Recommendation: Approve

Applicant: Mr & Mrs M Harland

Proposal: Two storey side extension, single storey rear extensions and alterations to the front porch

Drawing No.  
303/2019/01A

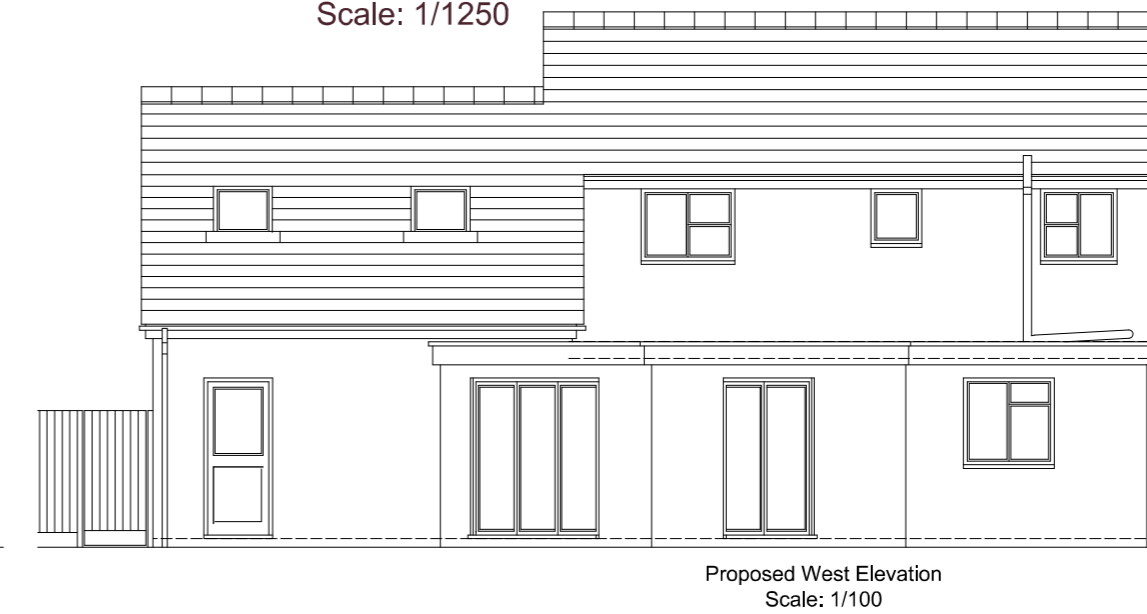
Arboriculture: **objection. Comments** – *The proposal does not appear to give reference to the trees north of the existing dwelling. The proposed extension is expected to offer significant short-term impact to the trees, likely requiring their removal in order to facilitate the proposal. Confirmation is required if trees are scheduled for removal or retention, I may need further information for review following this confirmation.*

Whilst the Council's Arboriculture Officer objected to the proposal, the existing tree within close proximity to the proposed development is identified on drawing number 303/2019/01A to be removed and replaced within the rear garden. Further, the trees to the north are outside the curtilage of the application site, approximately 19 metres from the nearest part of the extension. I therefore consider that the proposed development is acceptable despite their comments.
